Your ref: 3/2021/0275
Our ref: DC/21/1403
Date: 13-MAY-21

Location: Land behind The Dog Inn, Market Place, Longridge PR3 3RR
Proposal: Proposed erection of 9 new dwellings and associated works

Drainage and Existing and Proposed Levels – REQUEST FOR ADDITIONAL INFORMATION PRIOR TO DETERMINATION

Existing Site plan
1 : 200
0 1 5 10m

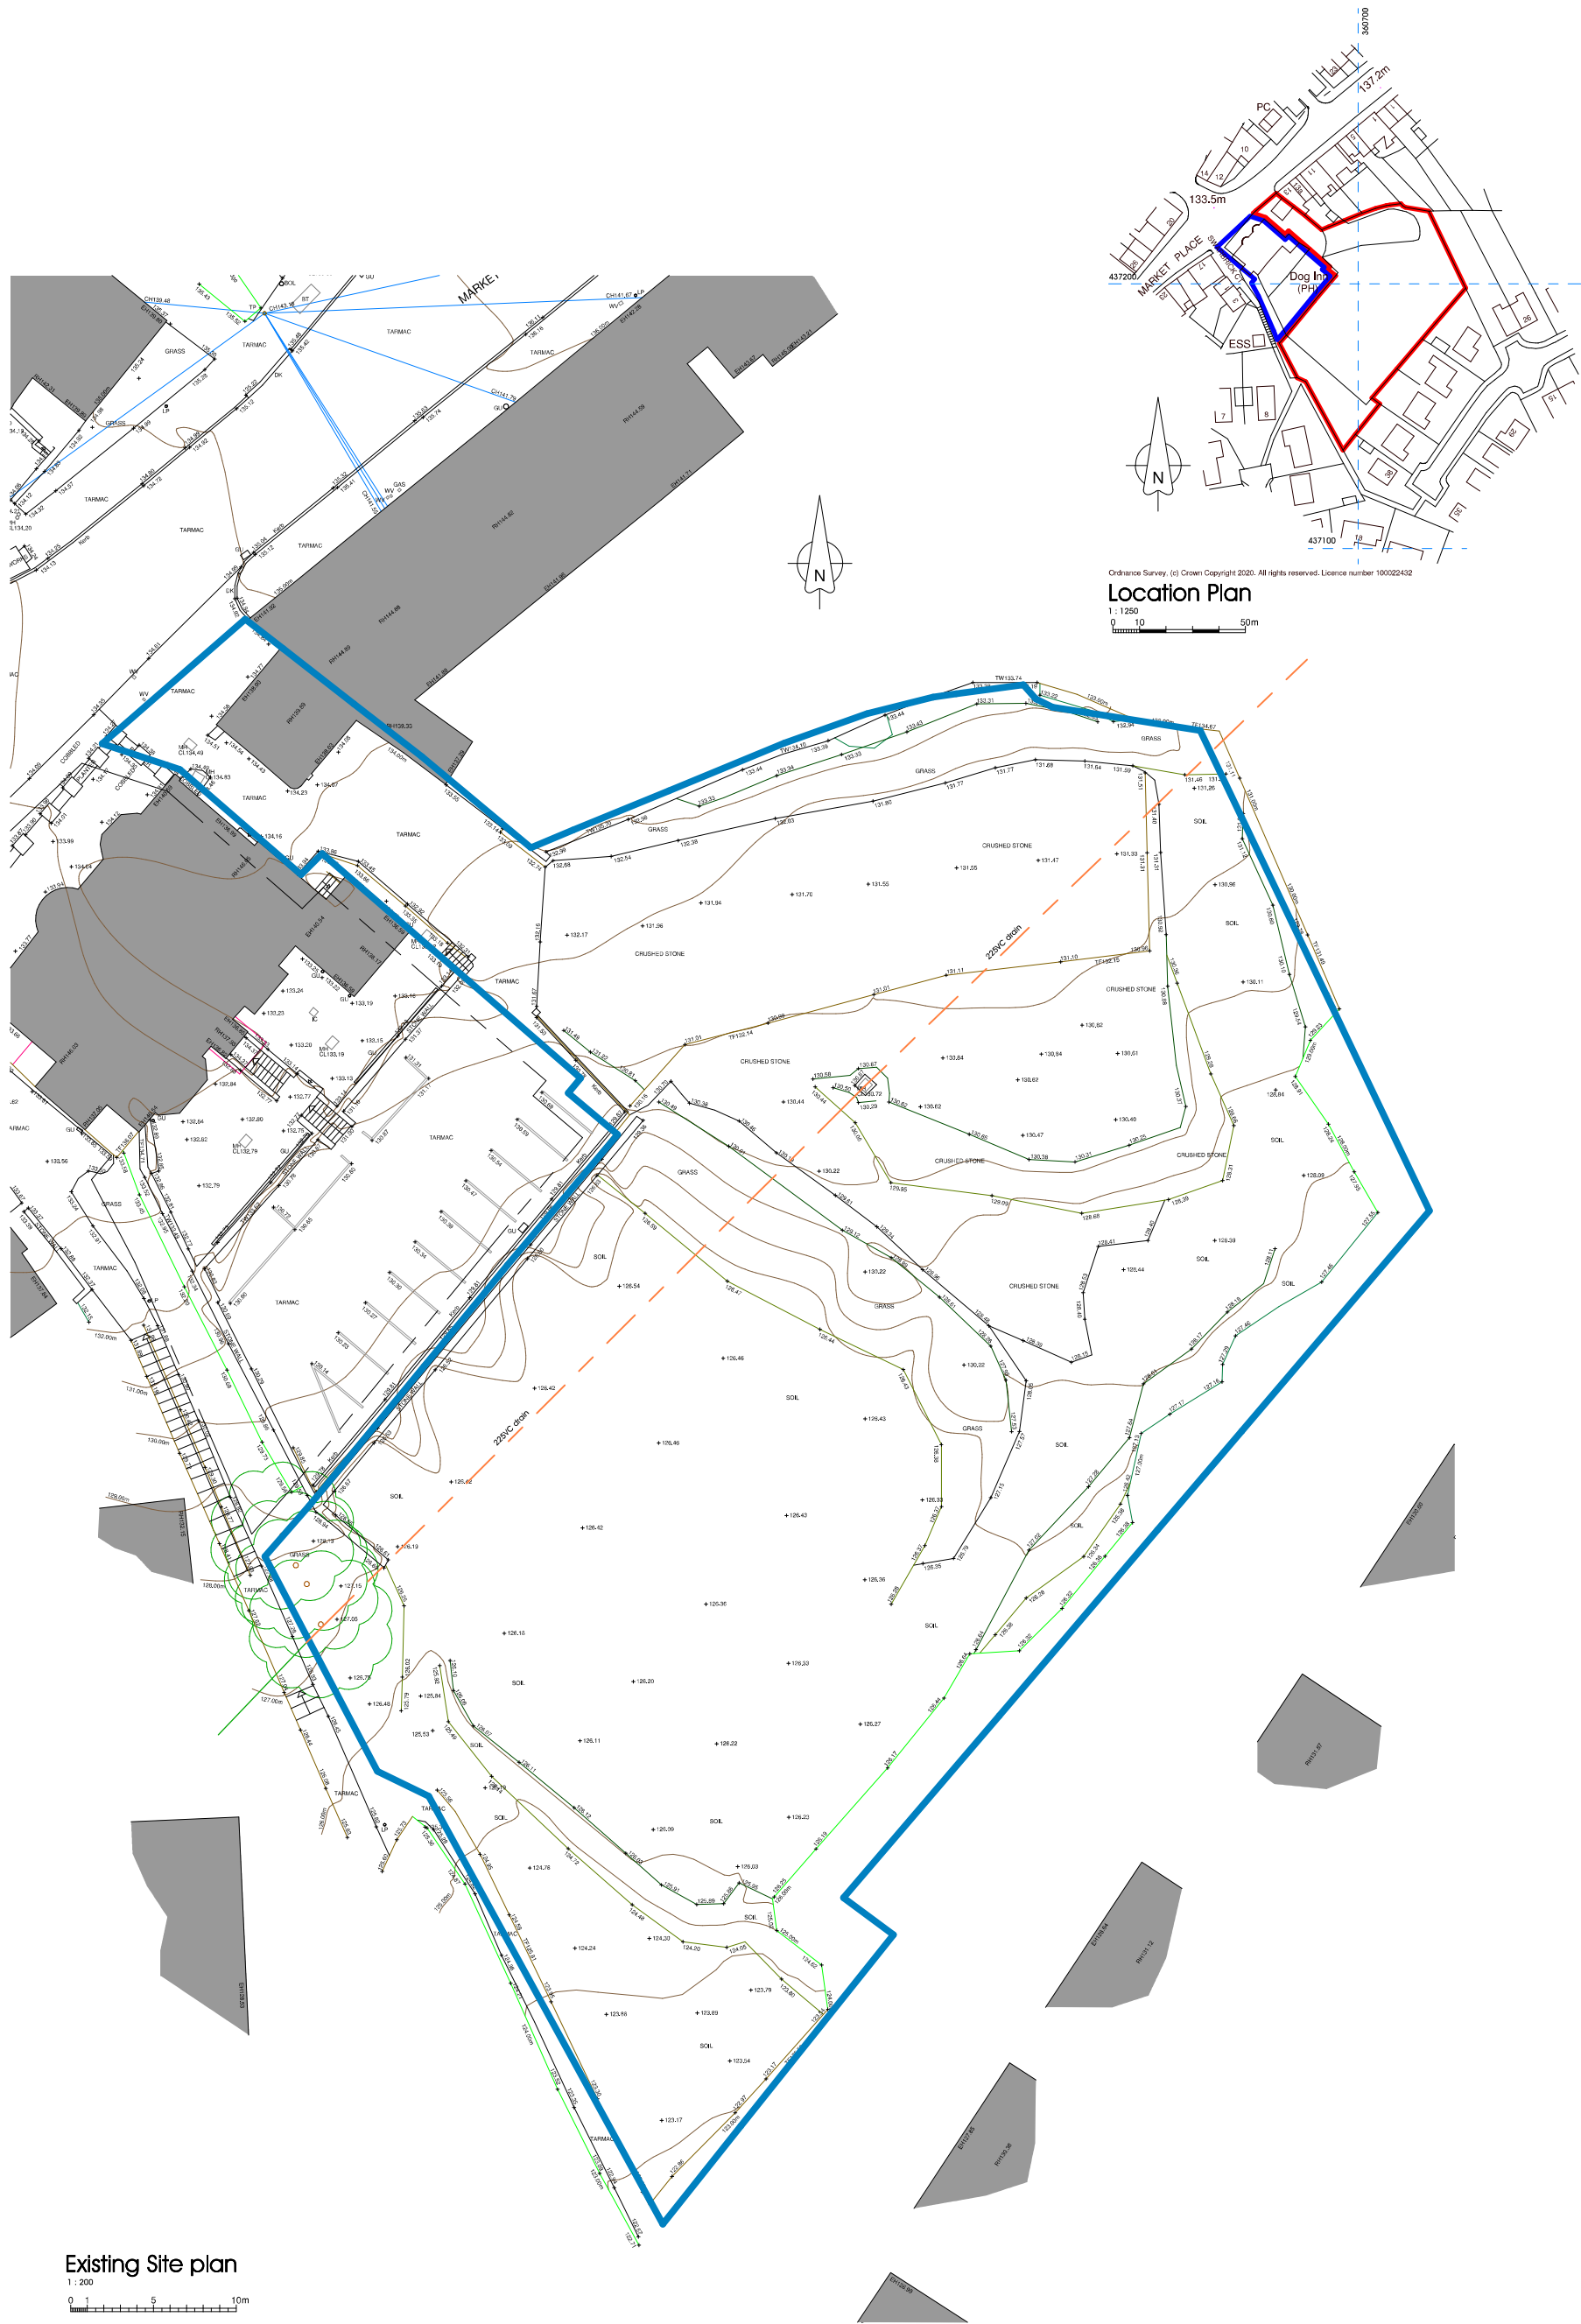
We wish to draw to the applicant's attention that the public sewer that passes through the site is a foul only sewer. In the event that infiltration is not feasible, there is no right to connect surface water to a foul only public sewer.

A public sewer crosses this site and we may not permit building over it. We will require an access strip width of six metres, three metres either side of the centre line of the sewer which is in accordance with the minimum distances specified in the current issue of Part H of the Building Regulations, for maintenance or replacement. Therefore a modification of the site layout, or a diversion of the affected public sewer may be necessary. All costs associated with sewer diversions must be borne by the applicant.

Site Section / Street Scene looking South West

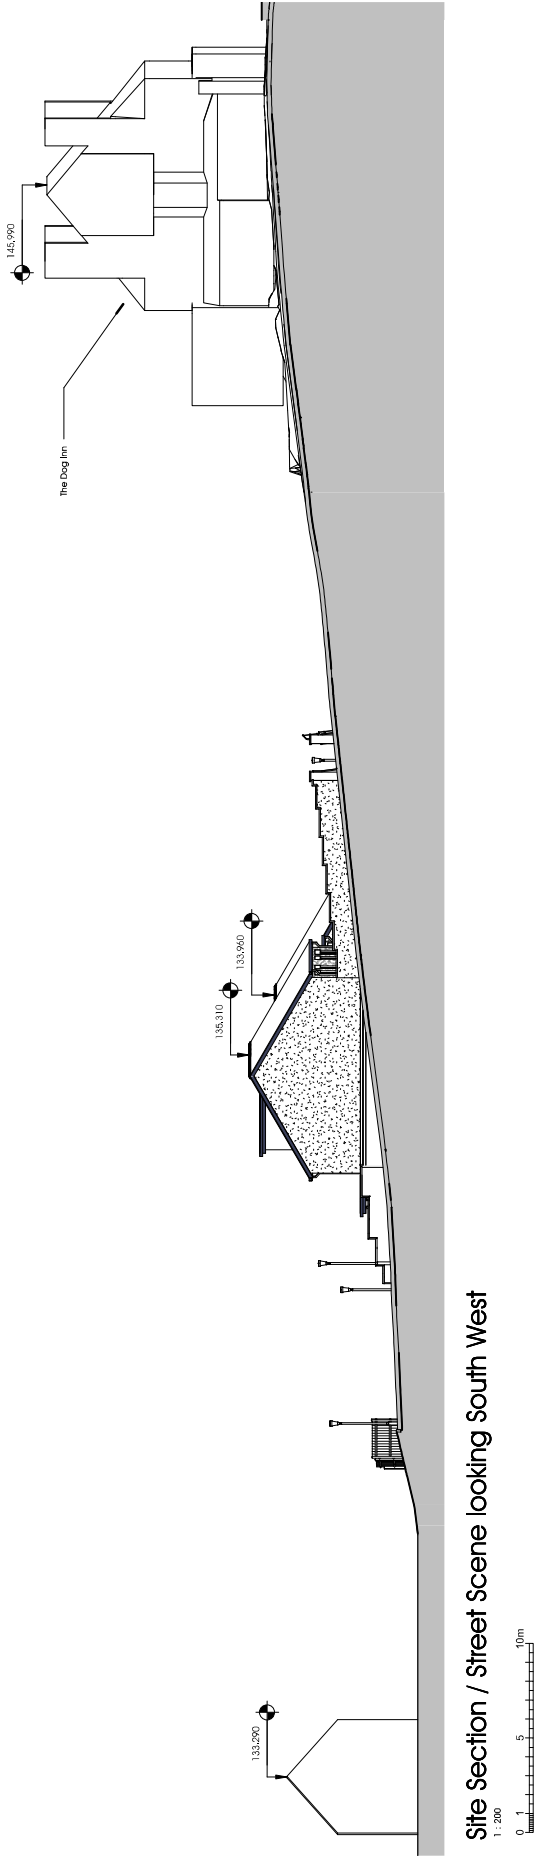
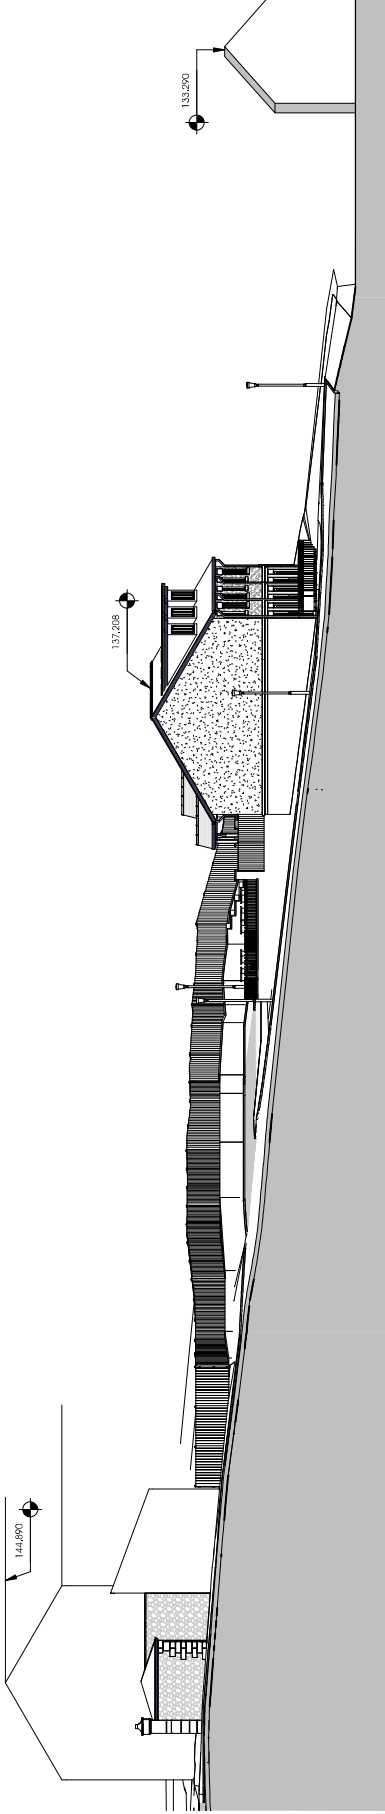
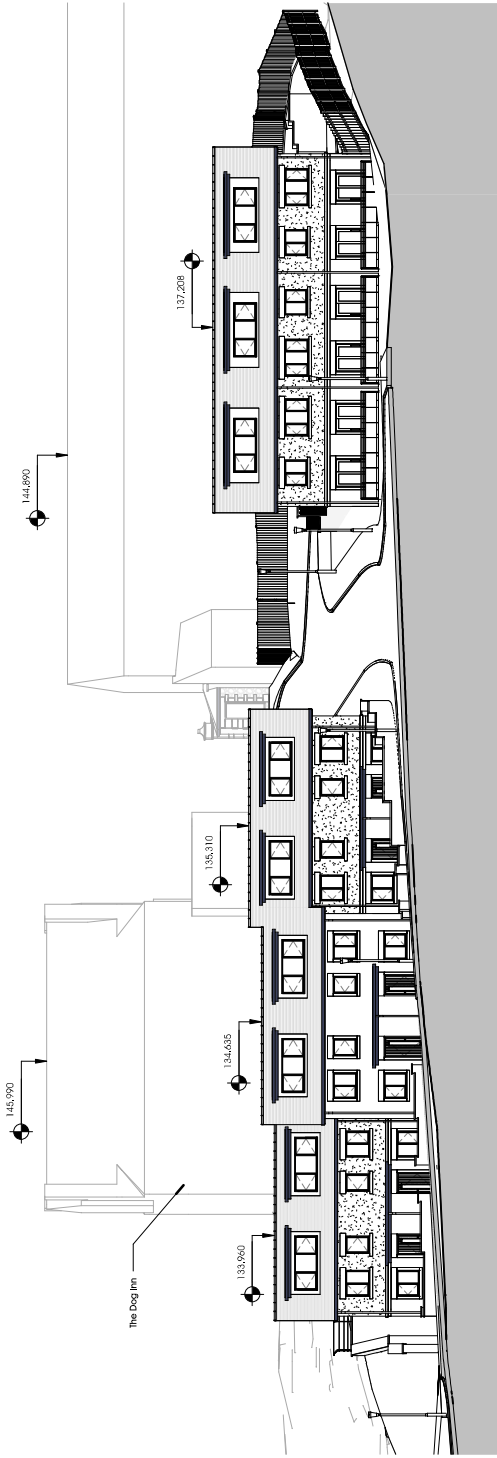
United Utilities has reviewed the submitted drainage information in respect of this full application for planning permission and requires the submission of additional information. We request that the applicant confirms the proposed finished floor and ground levels for the development in metres above ordnance datum. The reason for this request is because the topographic data suggests that some of the proposed properties will be at a lower level than the manhole cover level on the 225mm public sewer that passes through the site. For low-lying sites (where the ground level of the site is below the ground level at the point where the drainage connects to the public sewer) care should be taken to ensure that the properties are not at increased risk of sewer surcharge.

We also note the proposed stepped access to the properties which is in close proximity to the existing public sewer. We request that the applicant provides additional information so that the change in ground levels and the proposed stepped access can be fully understood in the context of our sewer. We will need to be afforded access to the public sewer for maintenance, repair and replacement. It is unclear from the plans if the required access strip of 6m (3m either side of the sewer, measured from the centre line) is being met. The applicant should note that a diversion may be necessary which is considered further below.
